DRB Application No.: **04DRB-01686 (P&F)**

Project # **1002702**

Project Name: **Iron Properties**

OFFICIAL NOTICE OF DECISION

PLAT OF TRACT 1 IRON PROPERTIES WITHIN SECTION 20, TOWNSHIP 10 NORTH, RANGE 3 EAST, N.M.P.M. CITY OF ALBUQUERQUE BERNALILLO COUNTY, NEW MEXICO NOVEMBER, 2004

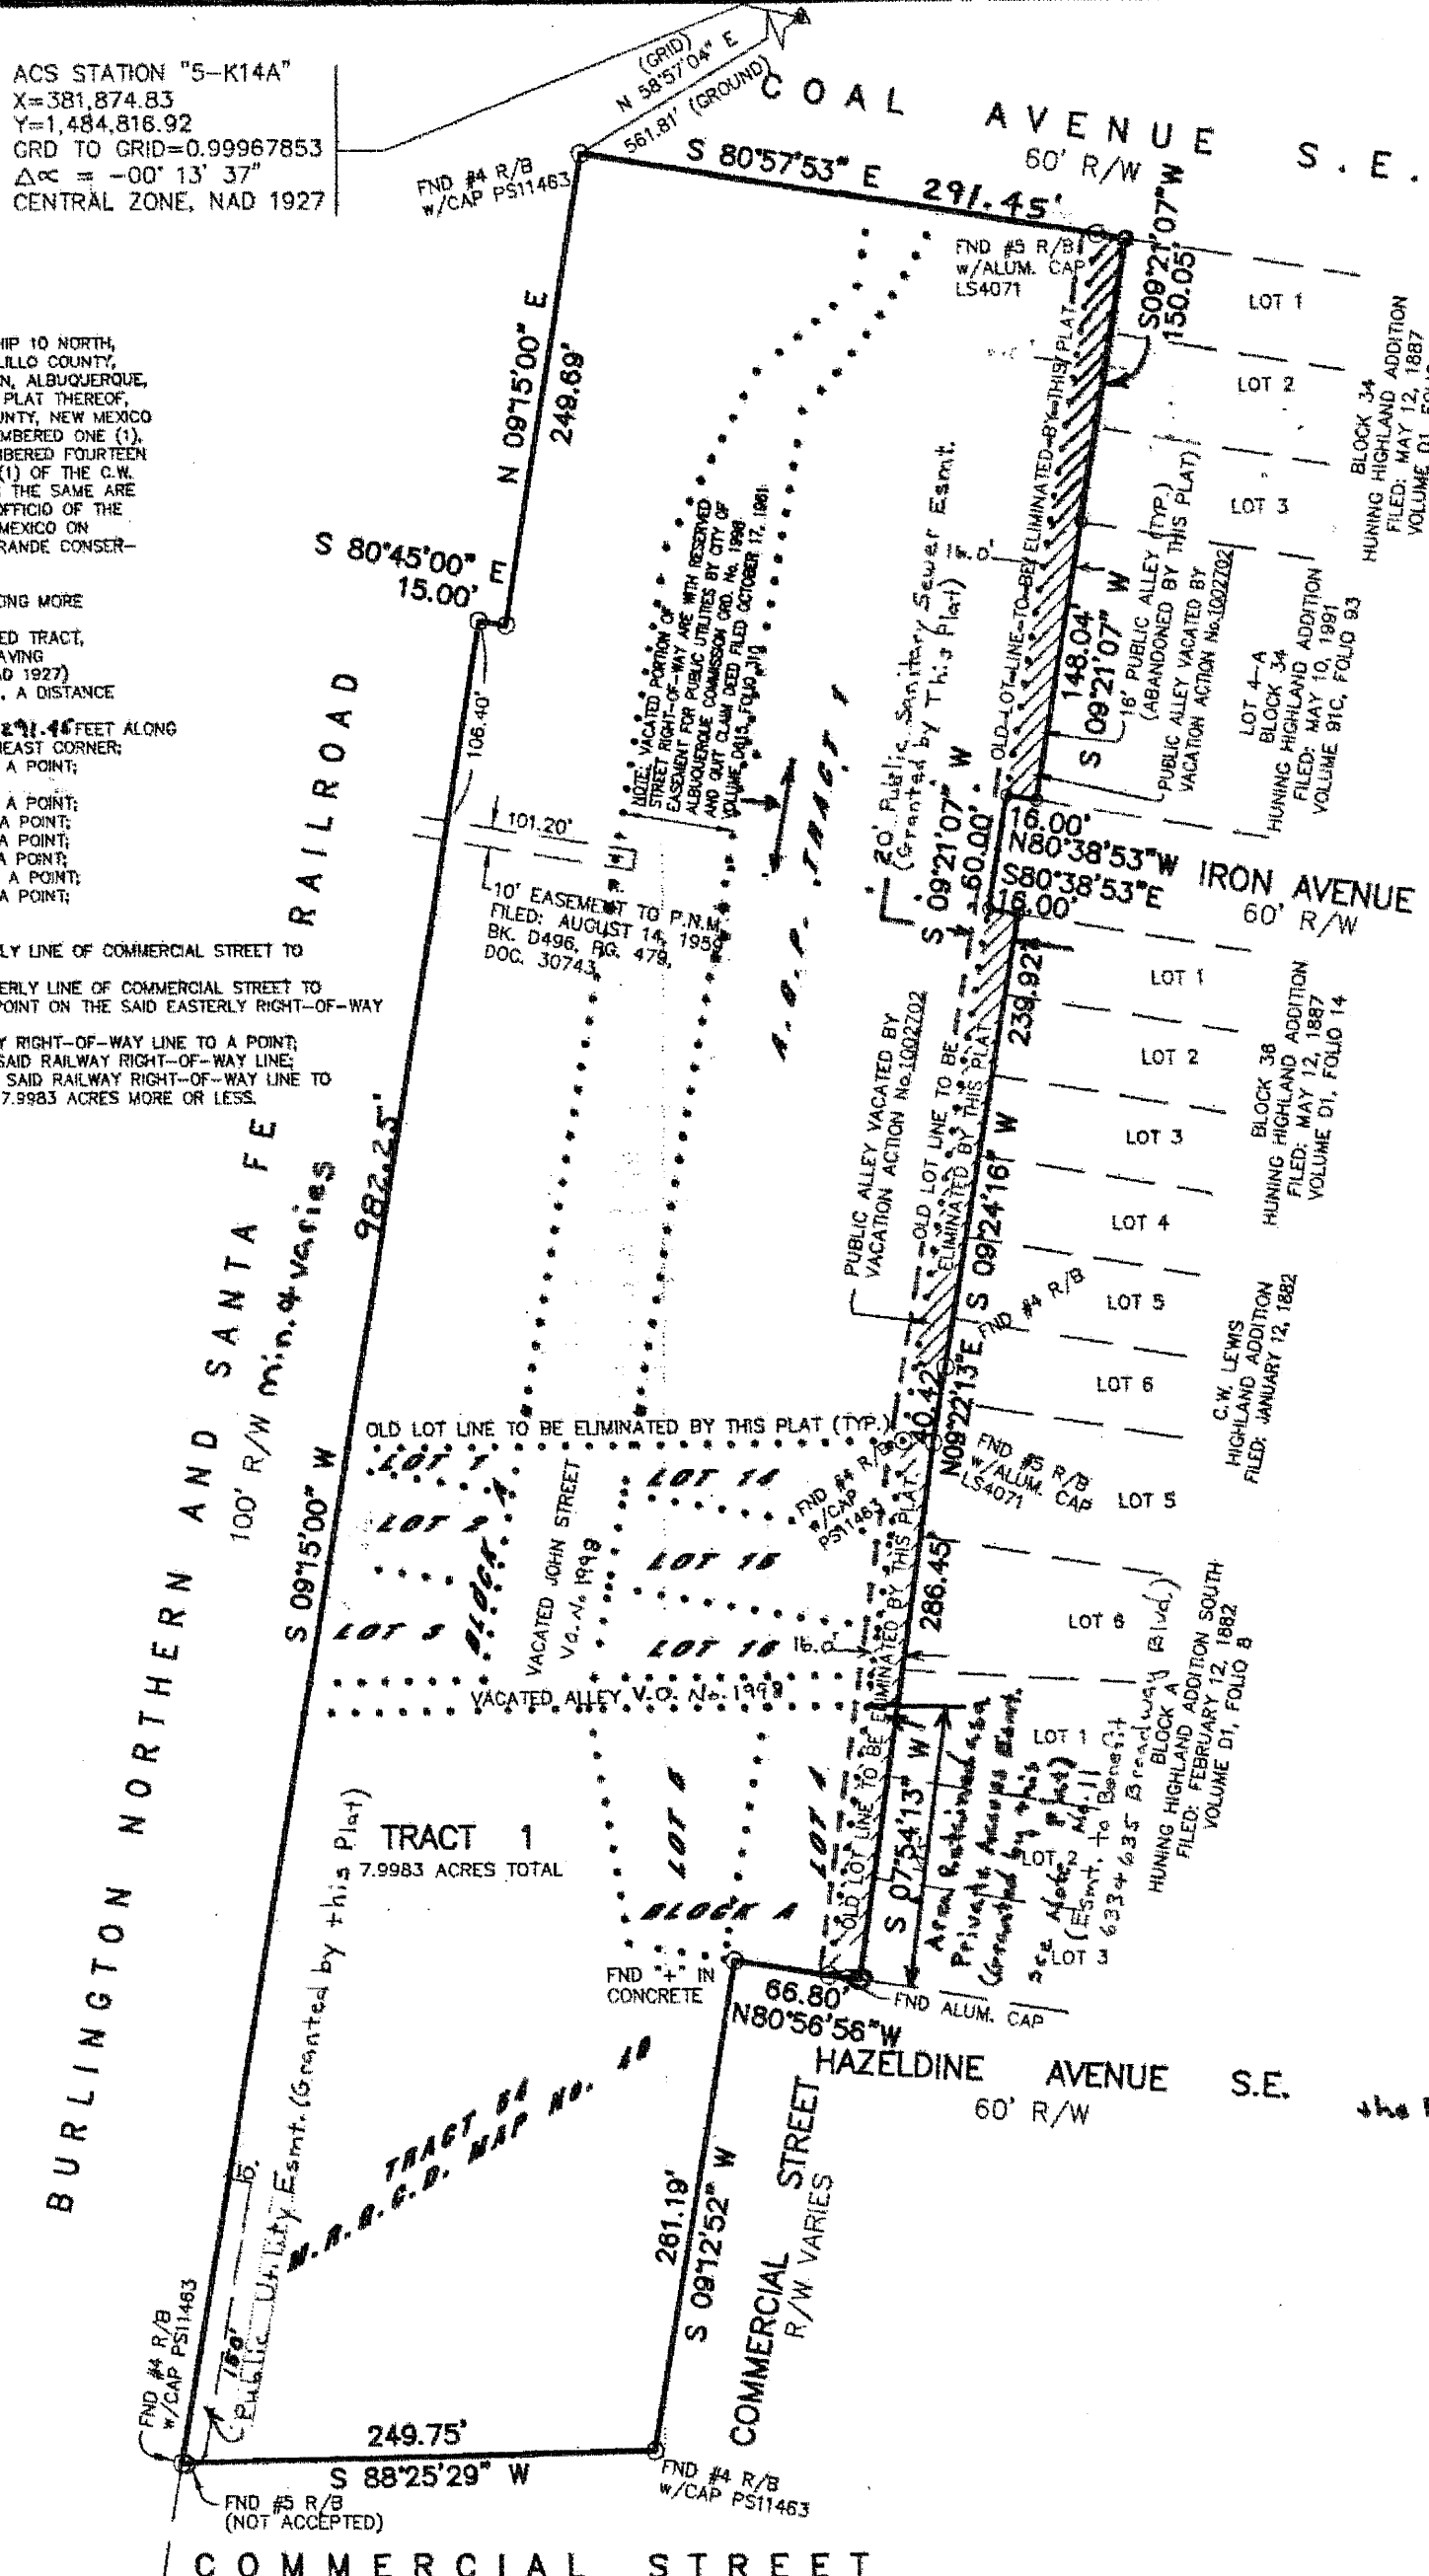
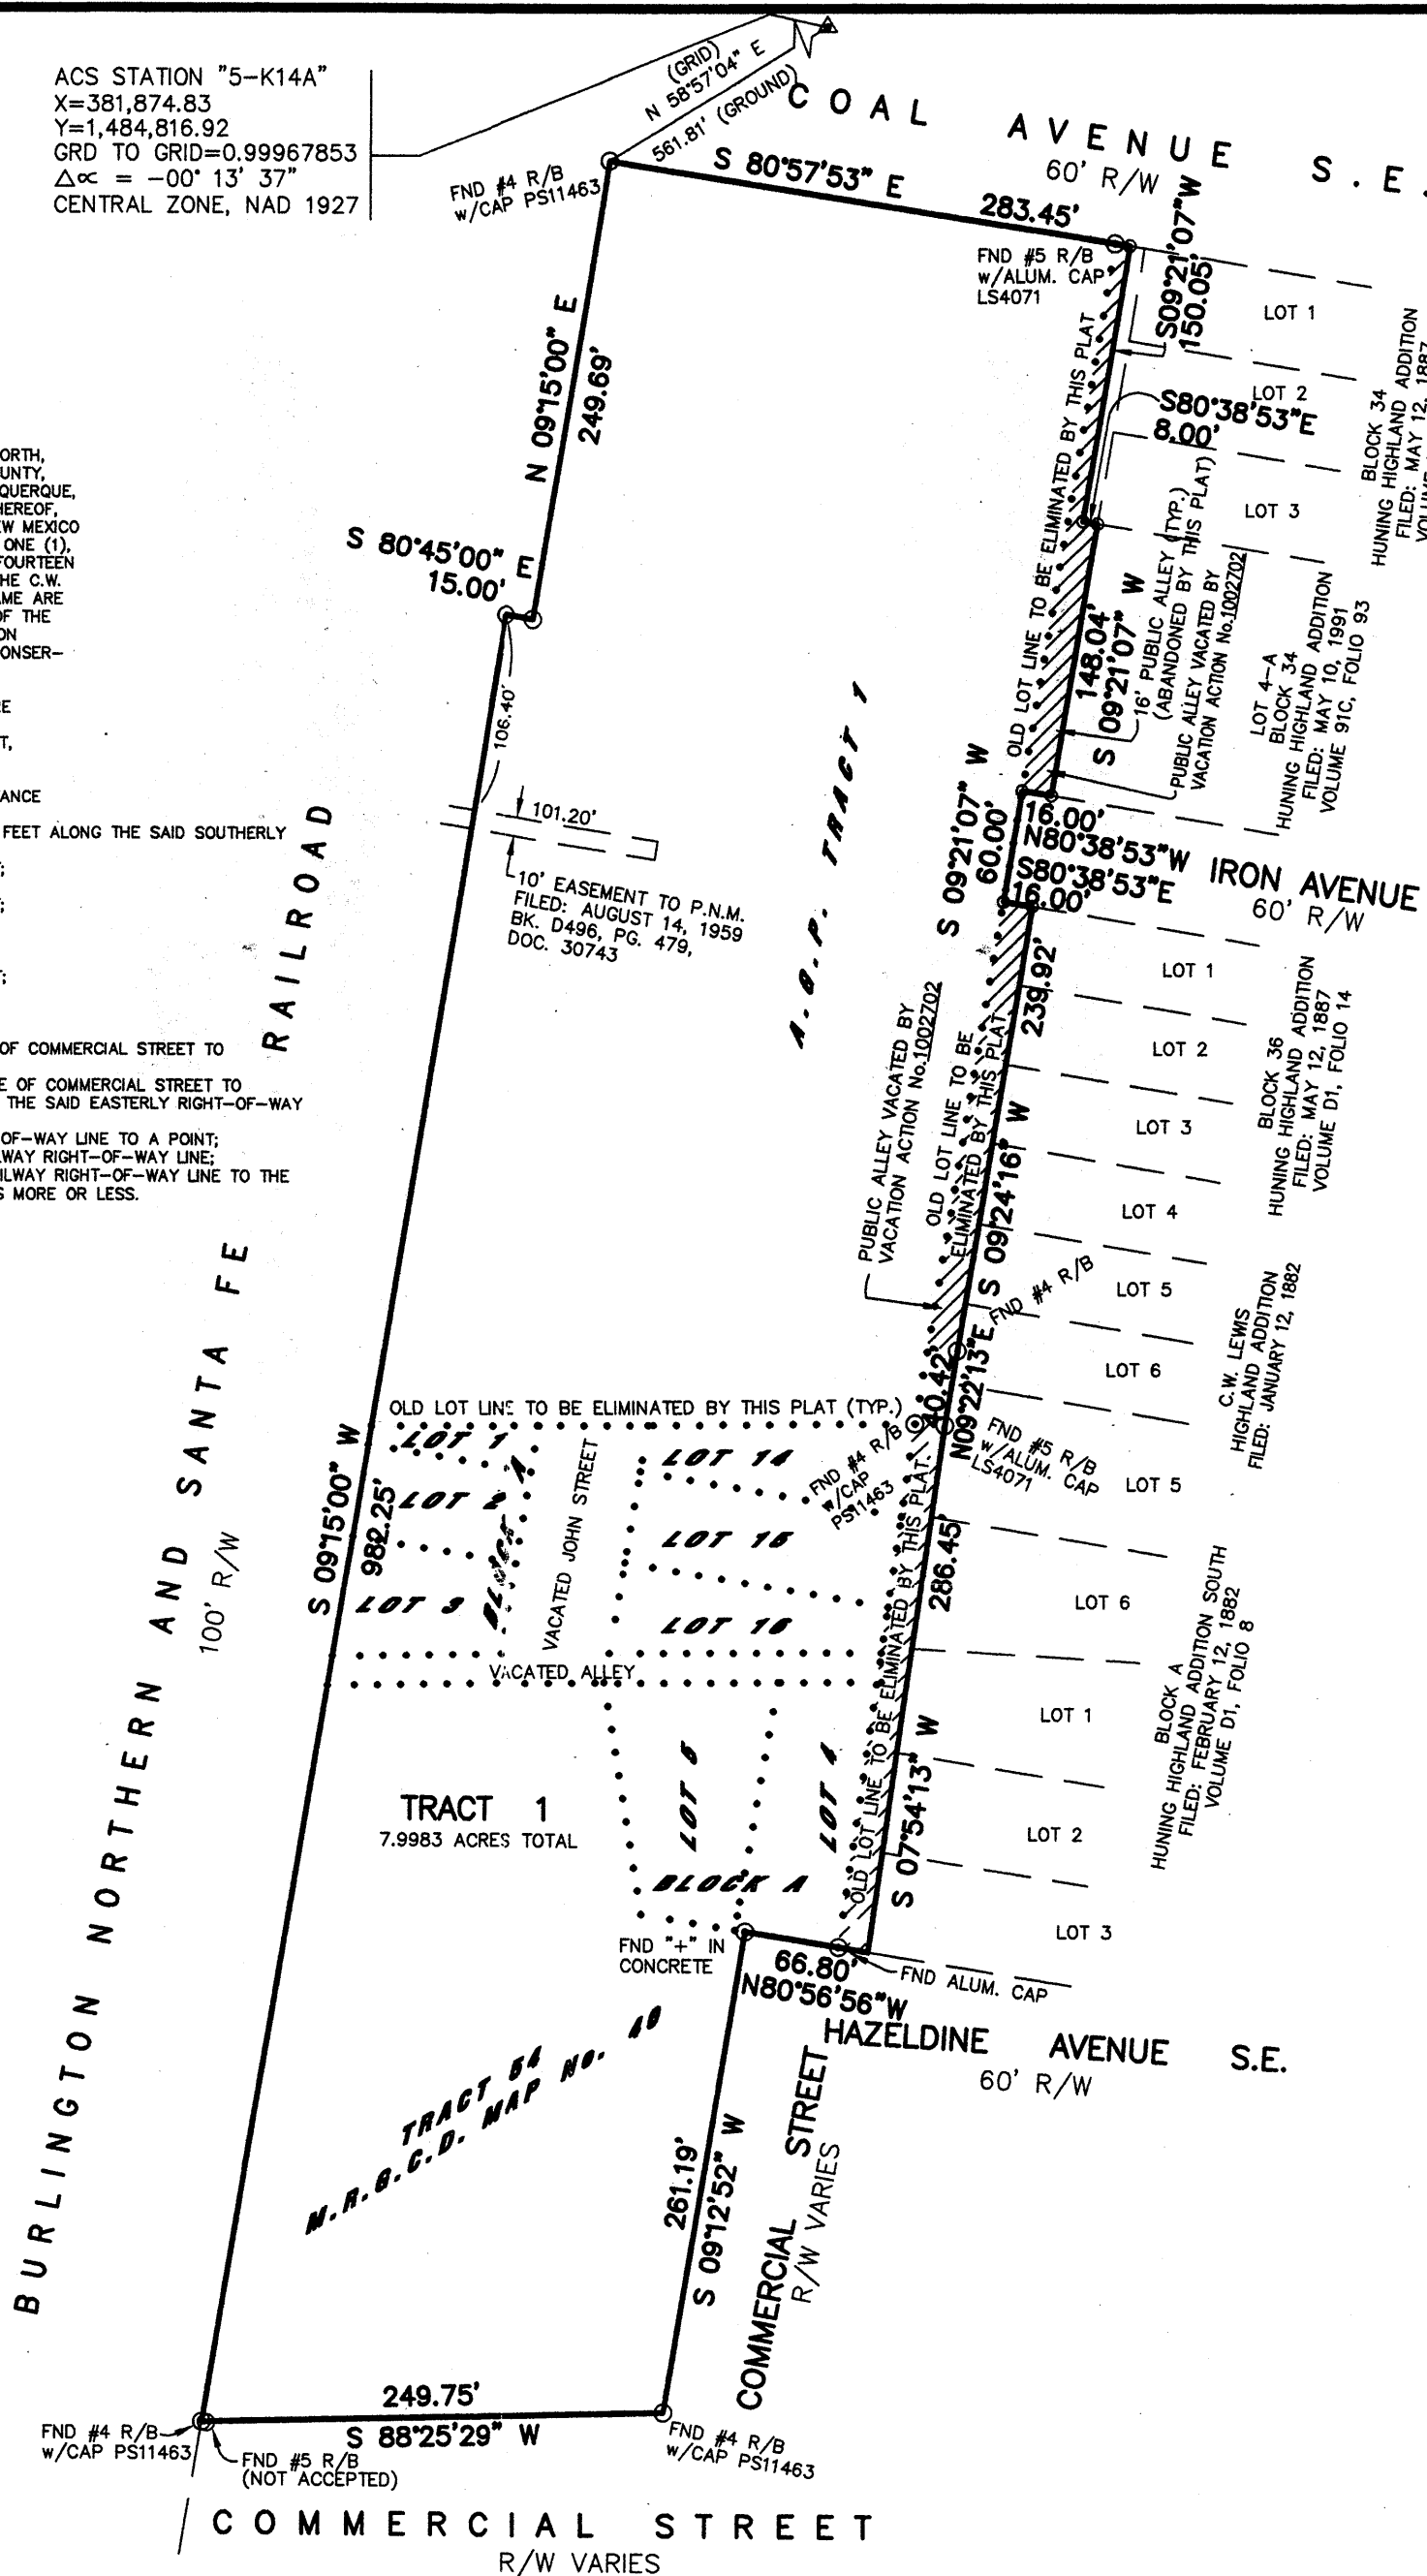
At the June 26, 2003 DRB hearing where this vacation was previously approved, applicant agreed to keep the portion of the north/south alley open between Hazeldine and the east/west alley as a result of adjacent property owners comments at the hearing. The plat does not appear to reflect this agreement.

In addition, these conditions of vacation were imposed: (1) an exhibit showing the location of the alley fencing is required at the time of plat approval; (2) the retention of adequate easements ~~for storm drain~~ and other utilities; (3) a survey showing the relation between the existing manholes and water meters, the alley and other utilities.

The plat shows "vacated John Street" and "Vacated Alley" in the middle section of the plat. A reference to the vacation action is needed. The public alley vacation action needs the Application number as well.

The Hydrology Section has no objection to the vacation request.
Need public easement for existing storm drain.

PNM has overhead facilities with the alley to be vacated. PNM will require
access and easements to maintain these facilities. Vacation OK if an
easement is granted to maintain facilities.

No objection to the vacation request. Plat must provide easements for public storm drain or owner must maintain onsite storm drain.

Where is the private access easement to 633 & 635 Broadway from Hazeldine? This was a condition of final plat. Provide exhibit relating addresses to lot numbers.

- a new 20' wide public sanitary sewer easement must be granted for the existing sanitary sewer line in the alley to be vacated. The Plat is not acceptable. It does not show the required easement for existing sewer line and does not show all of vacated John Street with utility easements that may have been retained. Need to see copy of Vacation Ordinance that vacated John Street.
